Our Ref: LU/248/19/DOC

Approval of details reserved by condition imposed under ref APP/C3810/W/18/3197149 (LU/162/17/PL relating to Condition Nos 8 - materials & finishes, 9 - landscaping scheme, 10 - Construction Management Plan, 13 - visibility splays, 14 - pedestrian visibility plays, 16 - cycle parking and 18 - street lighting.

Land At Toddington Farm North And West Of 1 To 3 Toddington Toddington Lane Littlehampton BN17 7PN

Arun District Council have decided to **REFUSE details reserved by condition for the following reasons:**

Construction Management Plan Layout

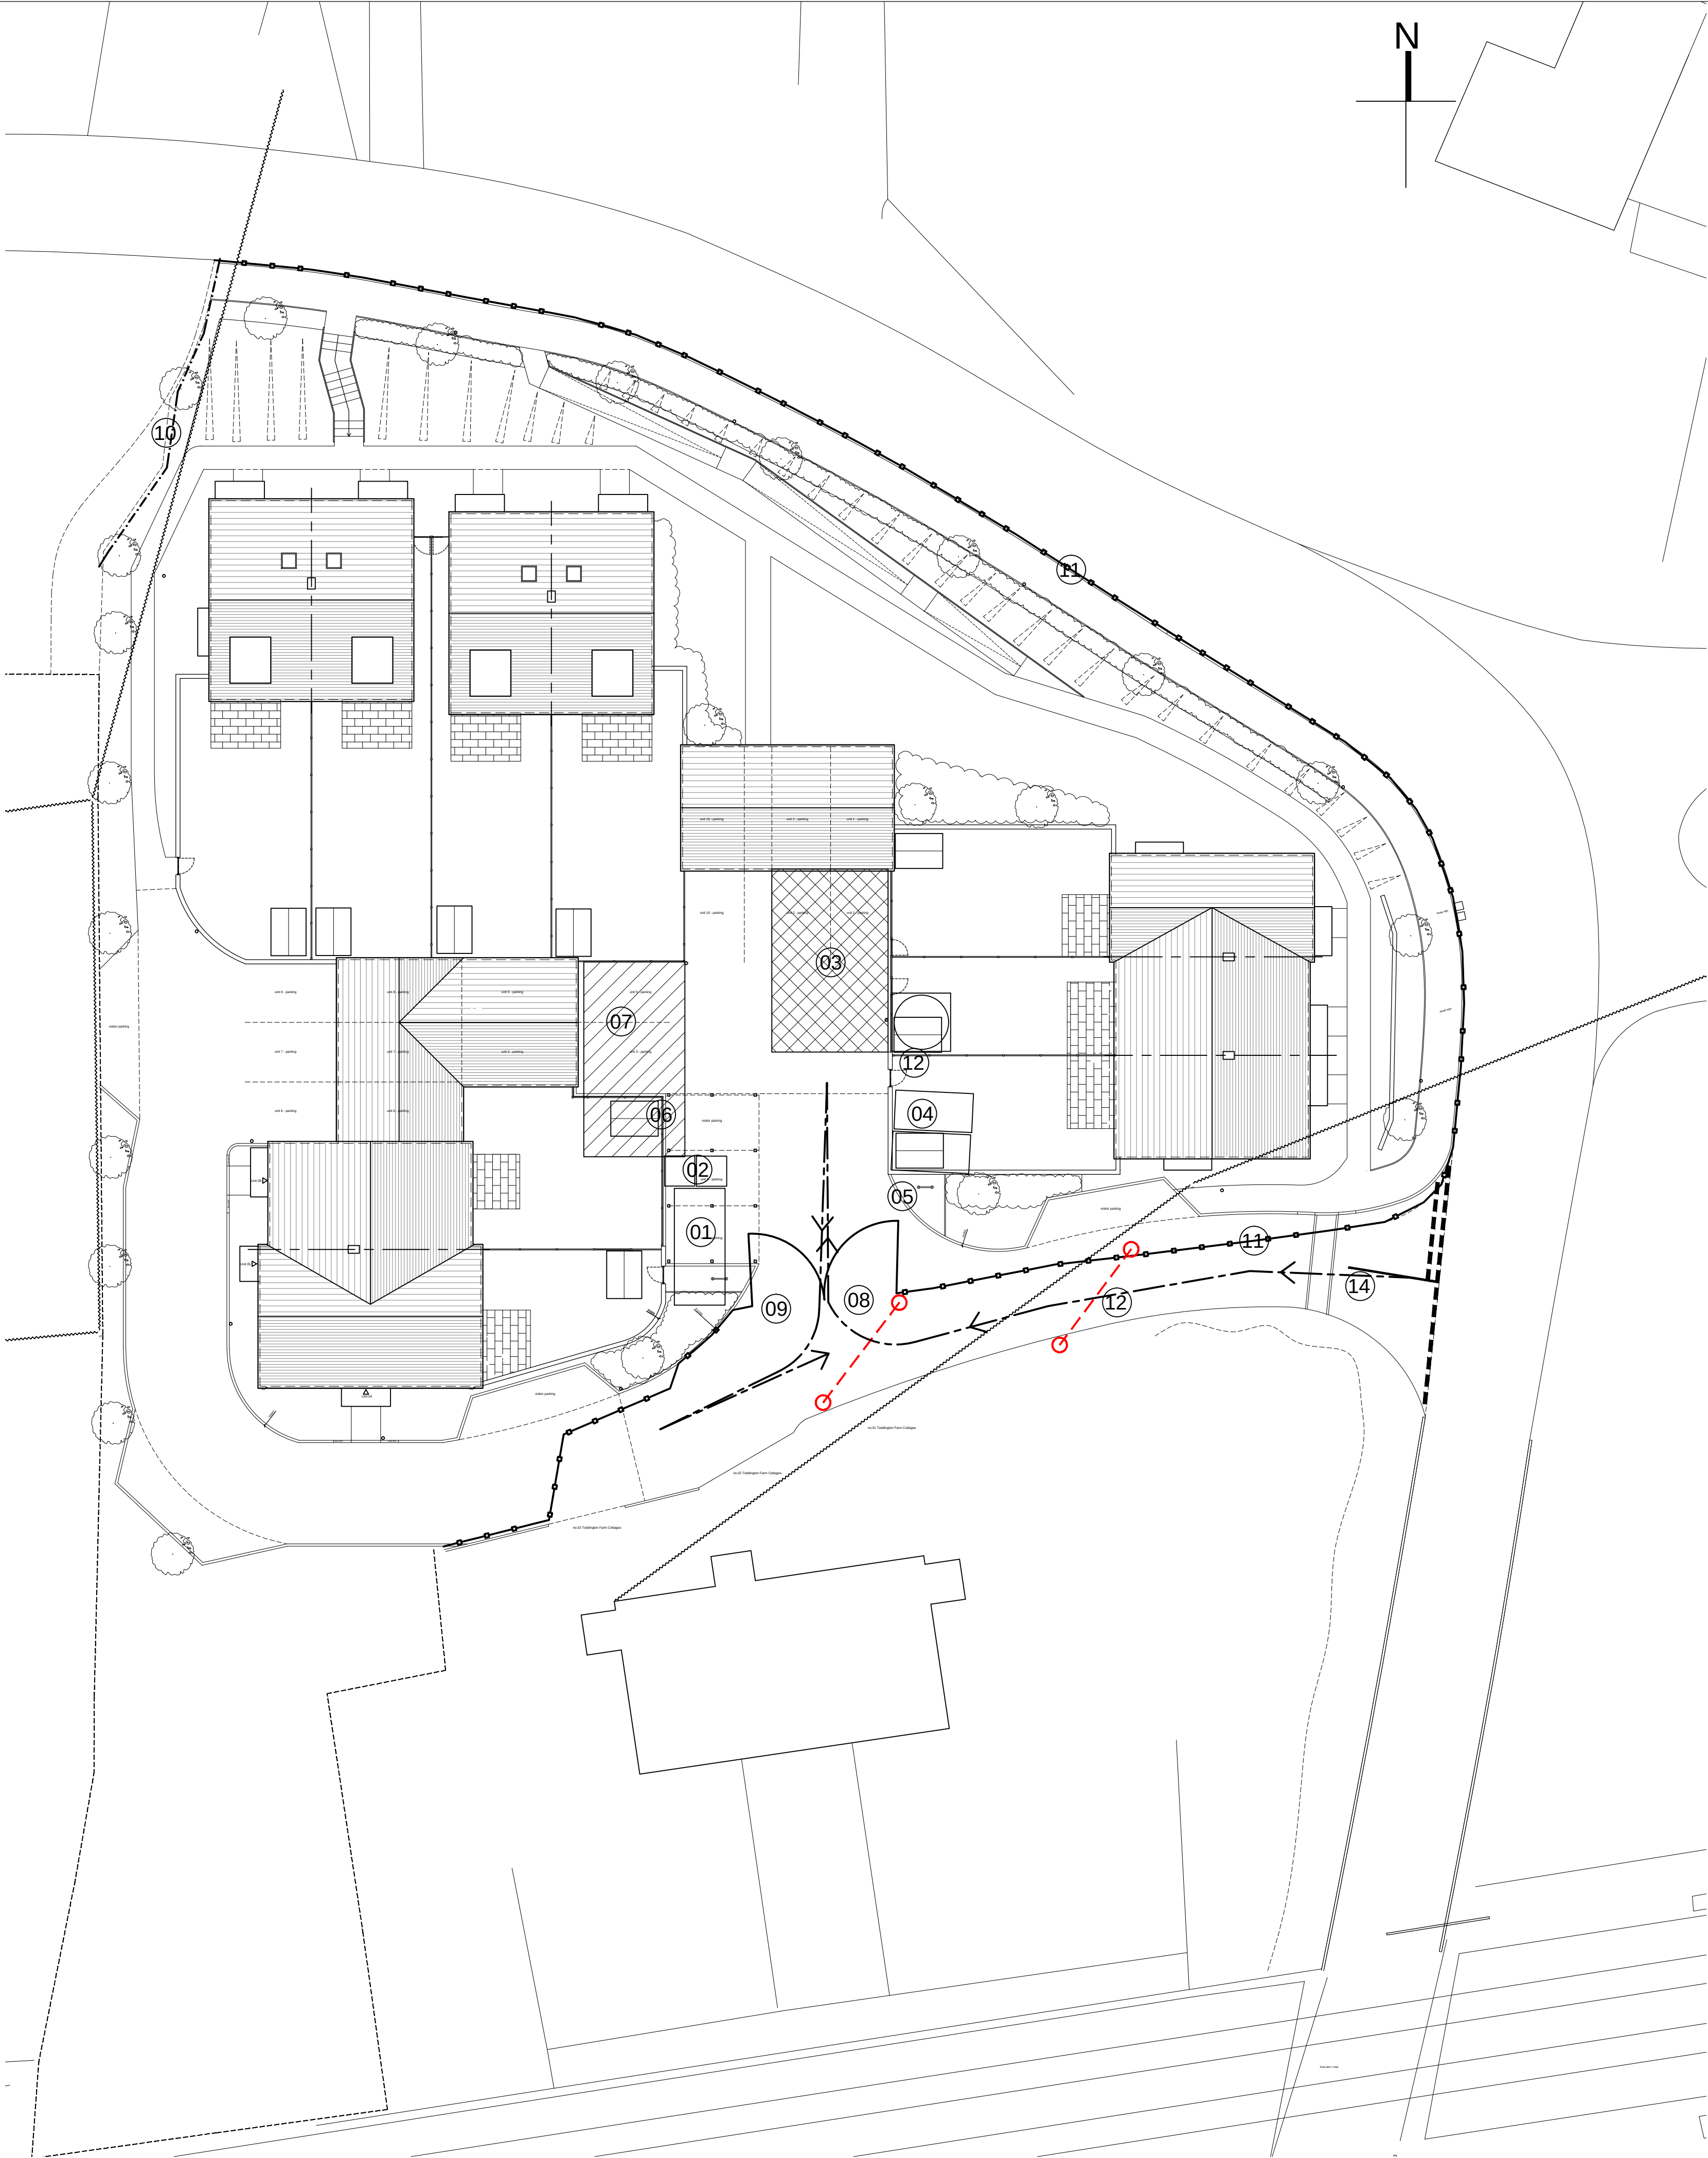
2.4 How will wheel wash water be disposed of?

- Construction routing plan to demonstrate no access to or from the south. All deliveries to enter from and leave to the north to avoid Toddington Lane and the adjacent railway crossing.
- A plan showing parking for contractors and visitors on the site clear of the public highway.

- A plan showing areas for materials storage on the site and clear of the public highway.
